From: Anita Gardner
Sent: 30 April 2018 09:03
To: Karen Parsons
Subject: FW: LY/3/18/HH and LY/4/18/L - Replacement Gates, Lyminster House, Church Lane

I refer to the above applications and can advise that the Conservation Officer has made the following comments:

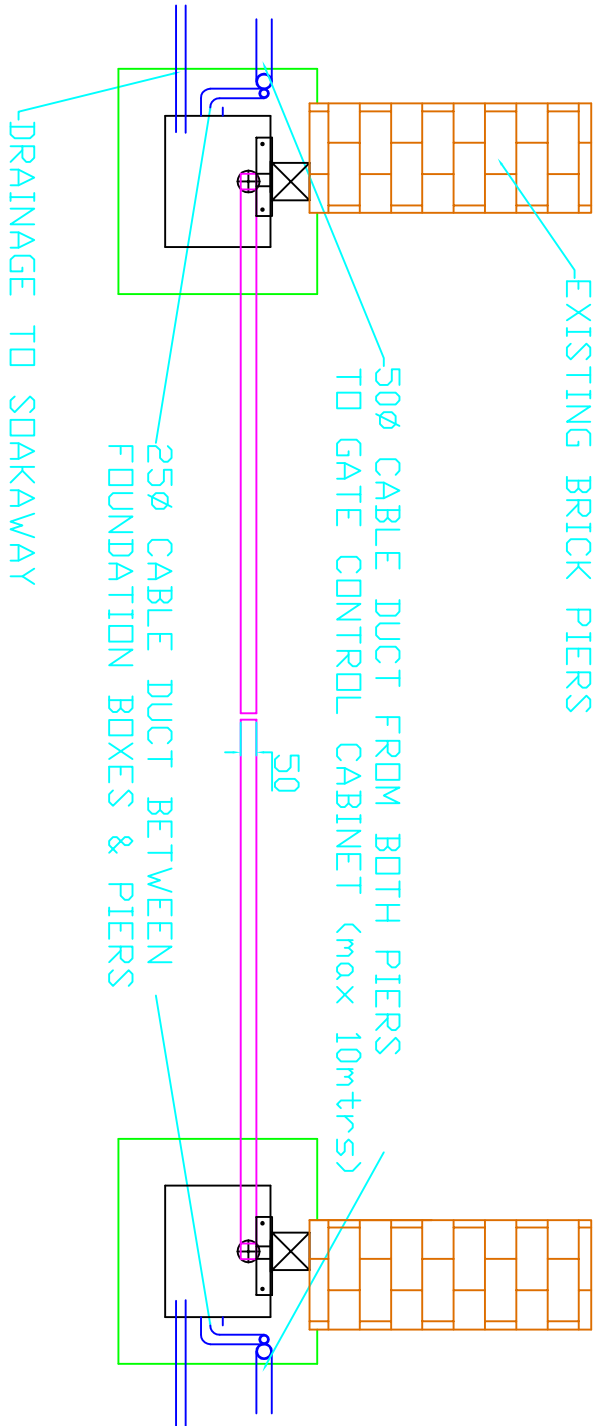
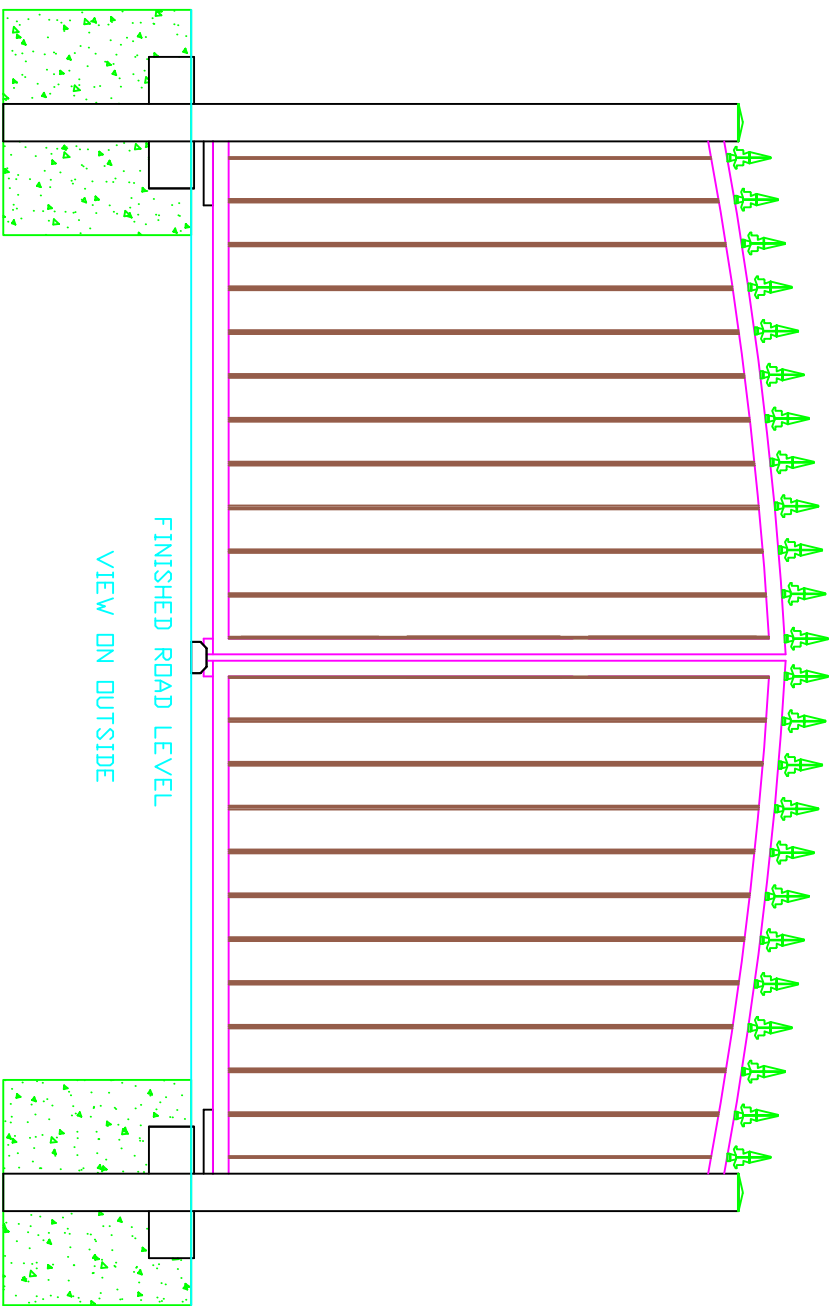
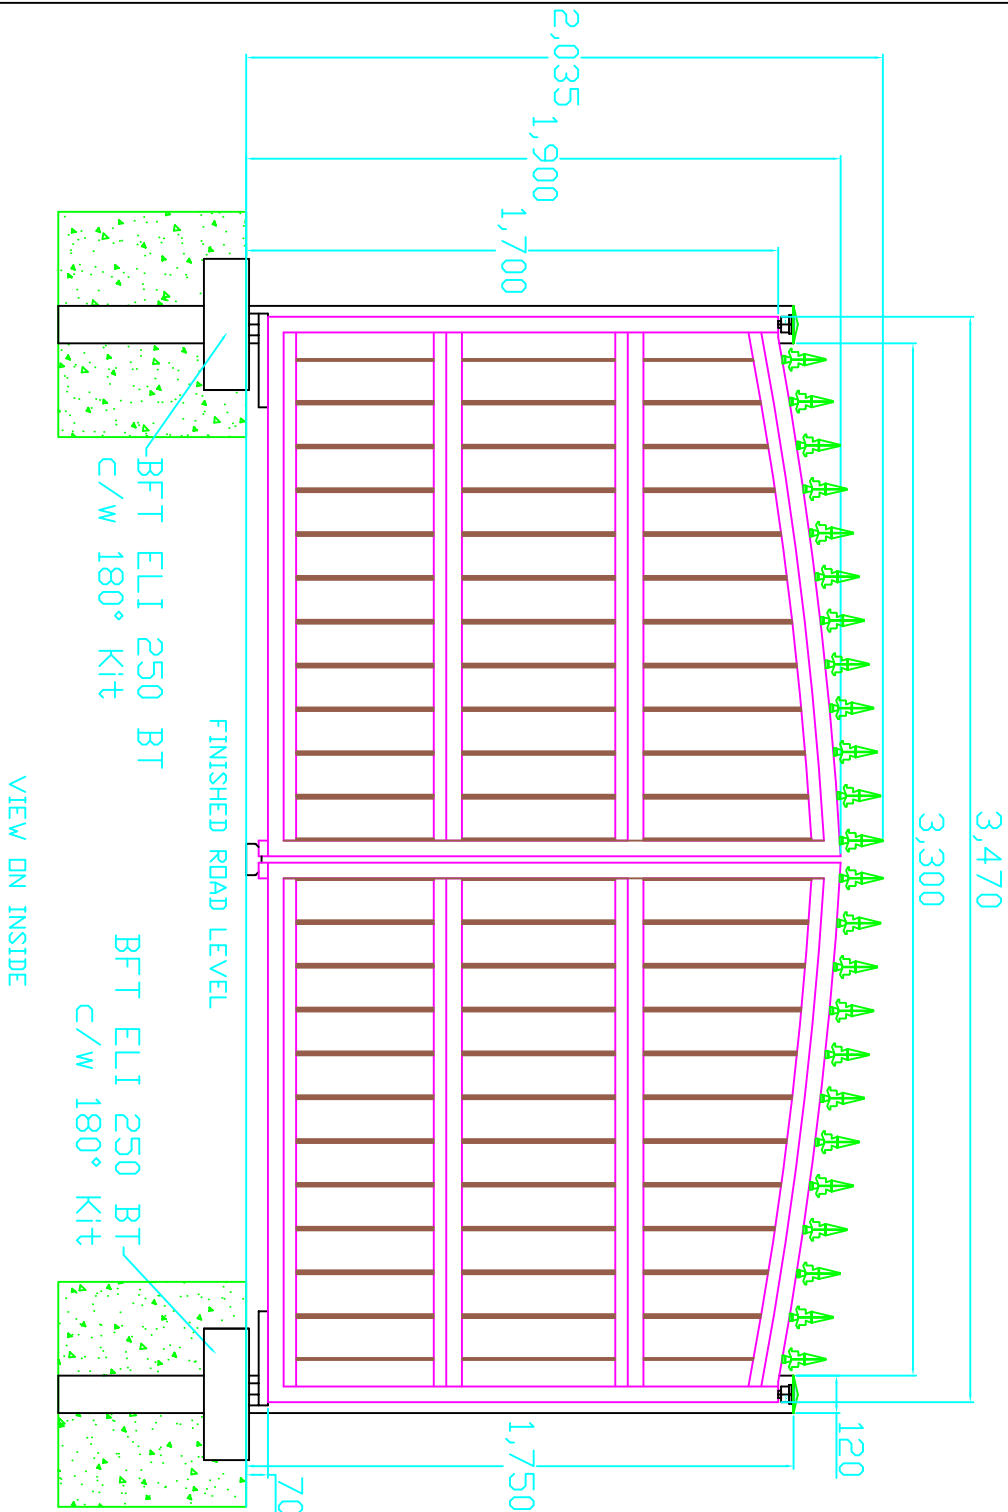
" While there is no objection in principle to the replacement of the gates, including an automation system, it is recommended that the profile of the replacement gate be either: horizontal to top edge, giving a more traditional profile OR downsweeping OR be metal gates. There is a concern that the new steel posts to support the proposed gates would be visually intrusive, and it is preferable that these be set to brick piers (concealing electrical works/mechanisms etc). Other than this, a manual gate could be fitted. I would currently recommend the proposed gates be refused."

I am very open to amending the design. I am not sure what is meant by "downsweeping" but certainly could amend to a horizontal design.

My preference was to use the historic hinge pins in the current brickwork located in the wall brickwork (rather than the piers themselves). However, as they are no longer "square" and their load bearing capacity questionable it would appear that this option would require a complete rebuild of the wall and piers. You will note that the current gates are hinged on timber posts.

The intention would be for the steel posts to be set behind the current brickwork piers such that these would not be at all visible from the street. Additionally, all supporting electrical junction boxing would be concealed on the rear of and at the foot of the current brick pillars, additionally concealed in existing vegetation.
